From: Laura Gibbons <Laura.Gibbons@arun.gov.uk>
Sent: 02 March 2021 09:53
To: Planning.Responses <Planning.Responses@arun.gov.uk>
Cc: Raymond Cole <Raymond.Cole@arun.gov.uk>
Subject: RE: Planning Consultation on: P/132/20/RES

Application No: P/132/20/RES

Site Address: Land north of Hook Lane Pagham

Description of Works: Approval of reserved matters following P/30/19/OUT for 300 No. new homes, internal roads, footpaths & cycleways, car parking & landscaping. This application affects the setting of a listed building & falls within Strategic Site H SP2, CIL Zone 1 (Zero Rated).

Project	Hook Lane, Pagham
Drawing	Site Layout
Client	Hallam Land
Job no.	HALL200505
Dwg no.	SL01
Author	AS
Status	PLANNING
Client ref.	
Date	June 2020
Revision	A
Scale	1:1000 at A1
Office	Romsey

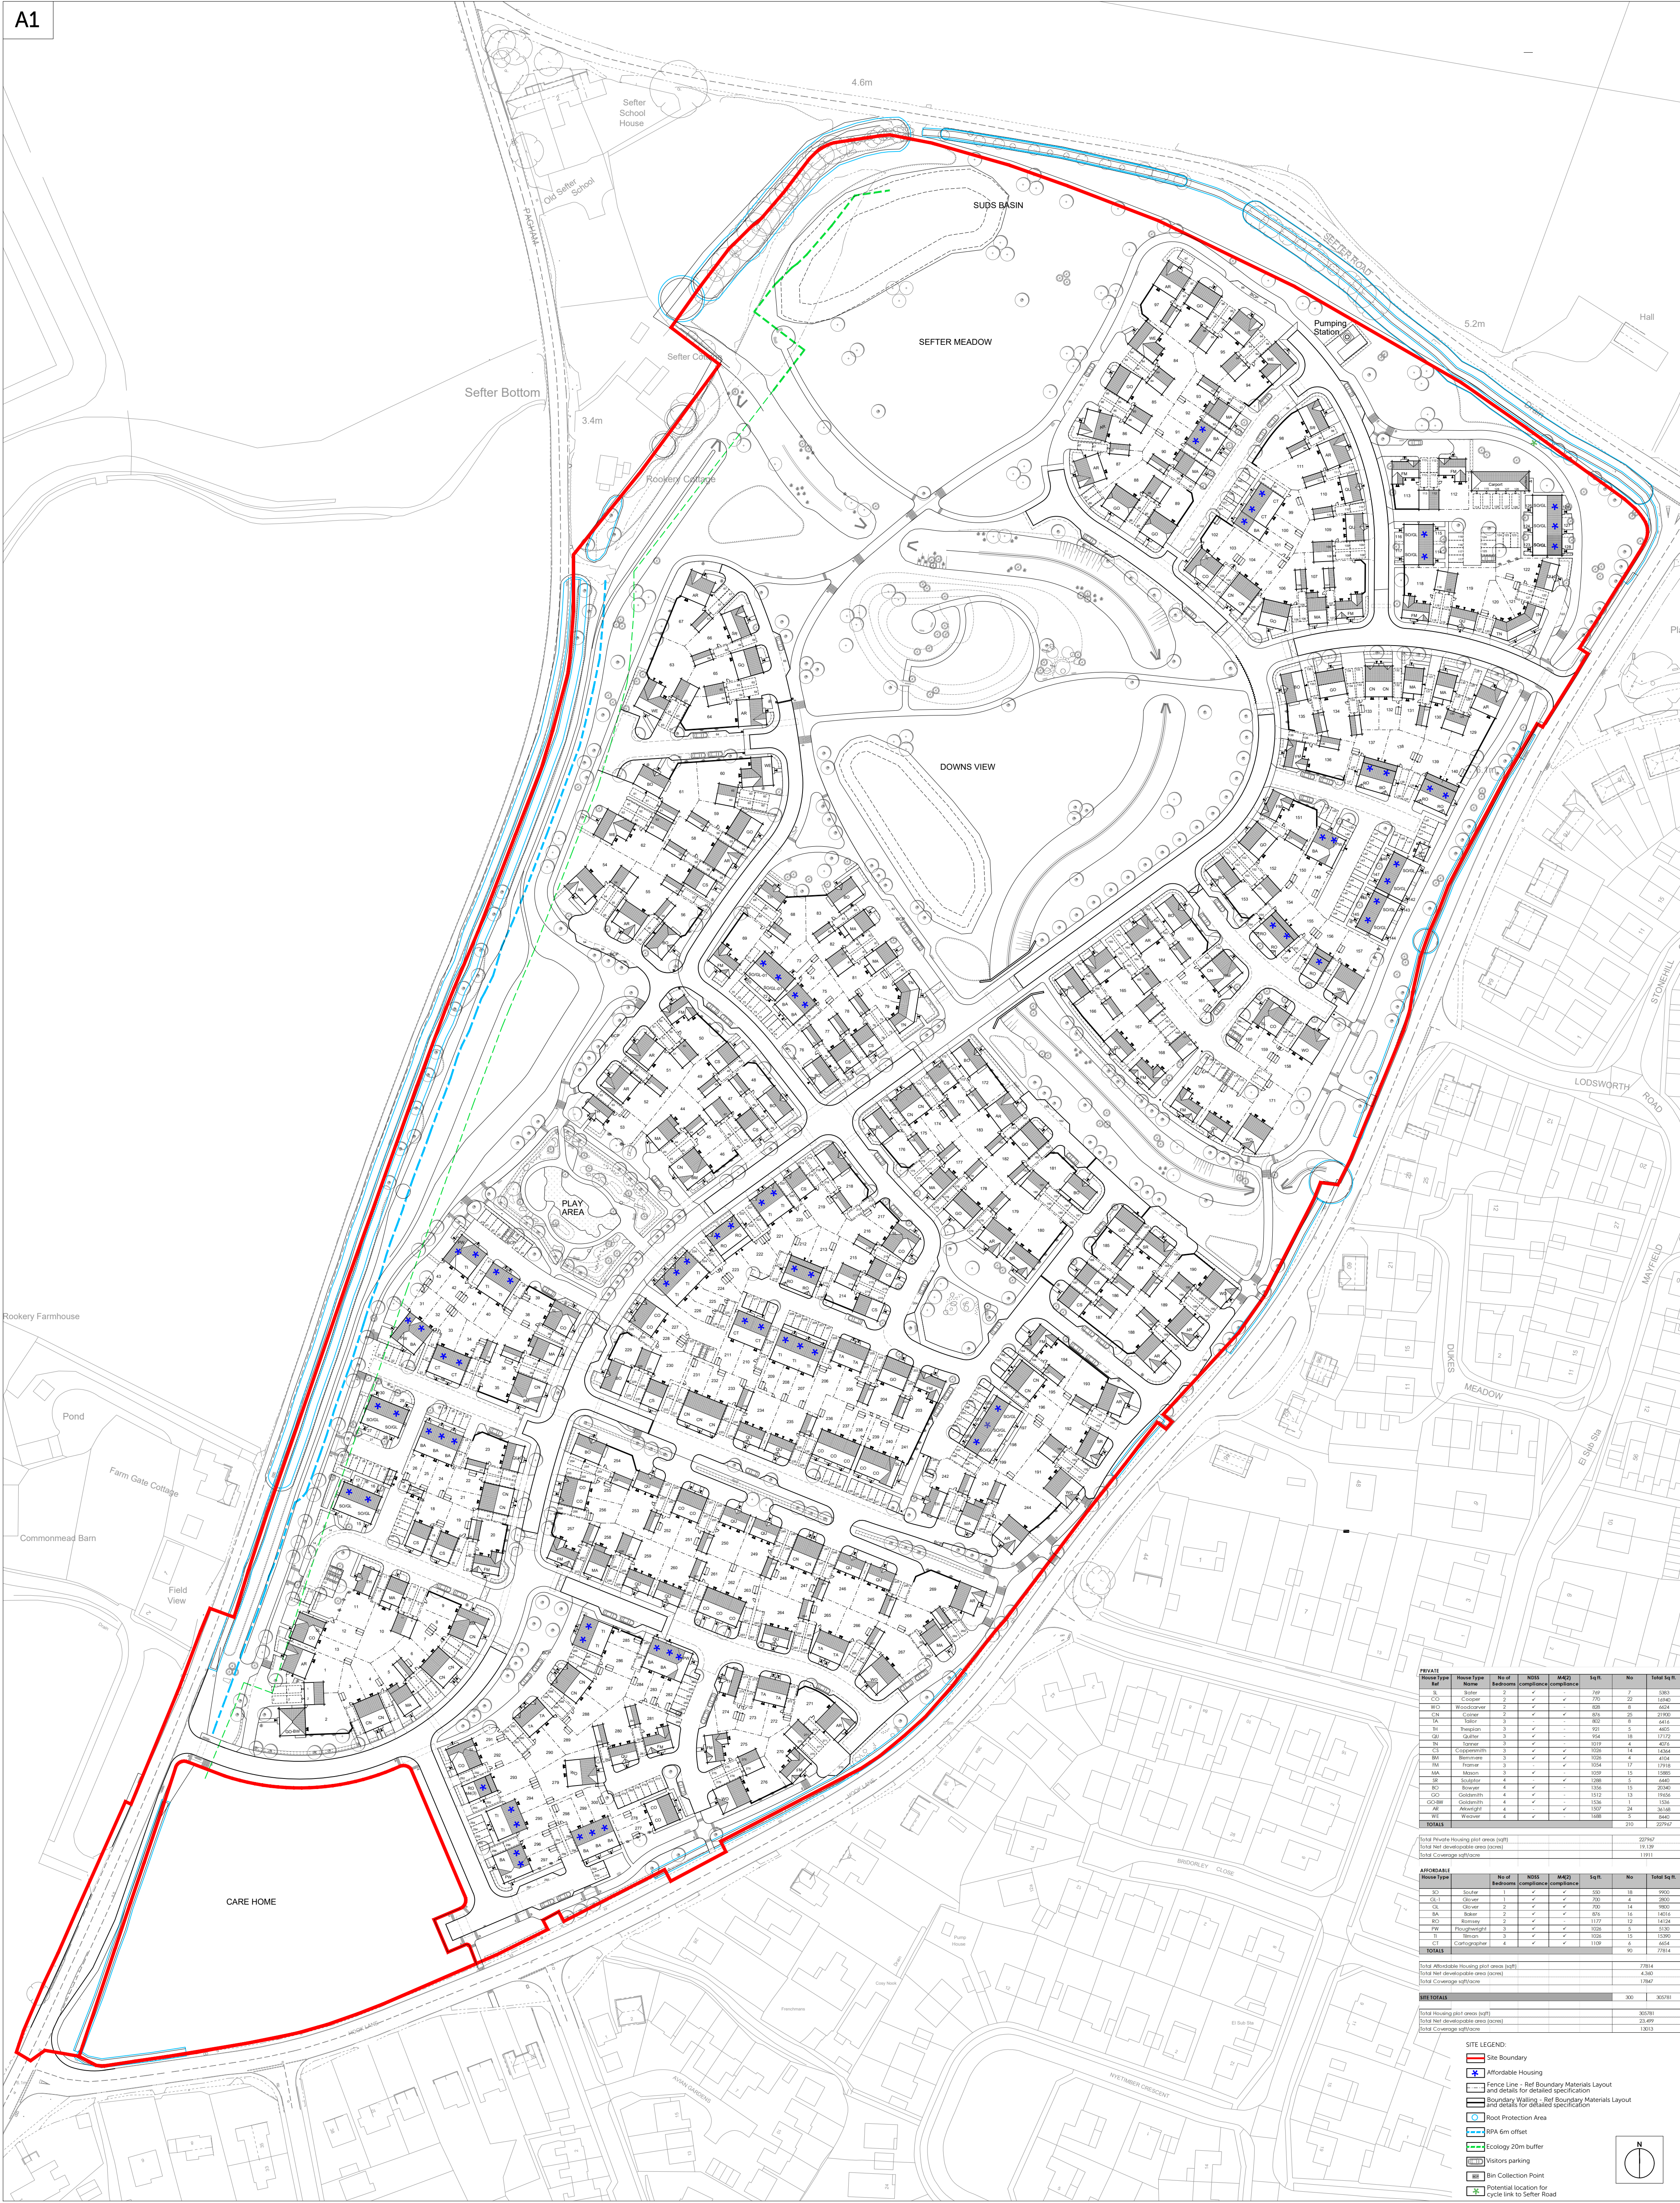
1. The proposed site layout includes the infilling of a watercourse which runs through the site. We do not support infilling or culverting of watercourses. Unless it is demonstrated that this watercourse is currently redundant we will not support proposals to infill it.
2. It is noted that a series of swales are proposed in close proximity to the existing watercourse mentioned in point 1 above. If it is proposed to bring the existing watercourse through the proposed drainage for the site it will be very difficult to evidence that the development is not increasing downstream flood risk unless controls are provided upstream of all connections into this swale. It is not clear from the drainage strategy

plan provided if this is the current proposal. Please can the applicant confirm if the proposed swales are for storage or are proposed to replace the existing watercourse and if flow controls will be in place upstream of all connections into this swale from the development.

4. A buffer plan should be provided evidencing that all proposed buildings/ features which will restrict access are at least 3m away from the top of bank of ordinary watercourse.

6. We note that the conveyance swale closest to Pagham Road is proposed to have one side formed of a bagwork retaining wall. The proposed site layout should be sufficient to facilitate natural slopes at 1 in 4 for all basins and swales. The layout should be adjusted to achieve this and remove the requirement for a retaining structure.

7. The proposed drainage strategy shows all water discharging to one location. The surface water drainage strategy must follow existing natural catchments.
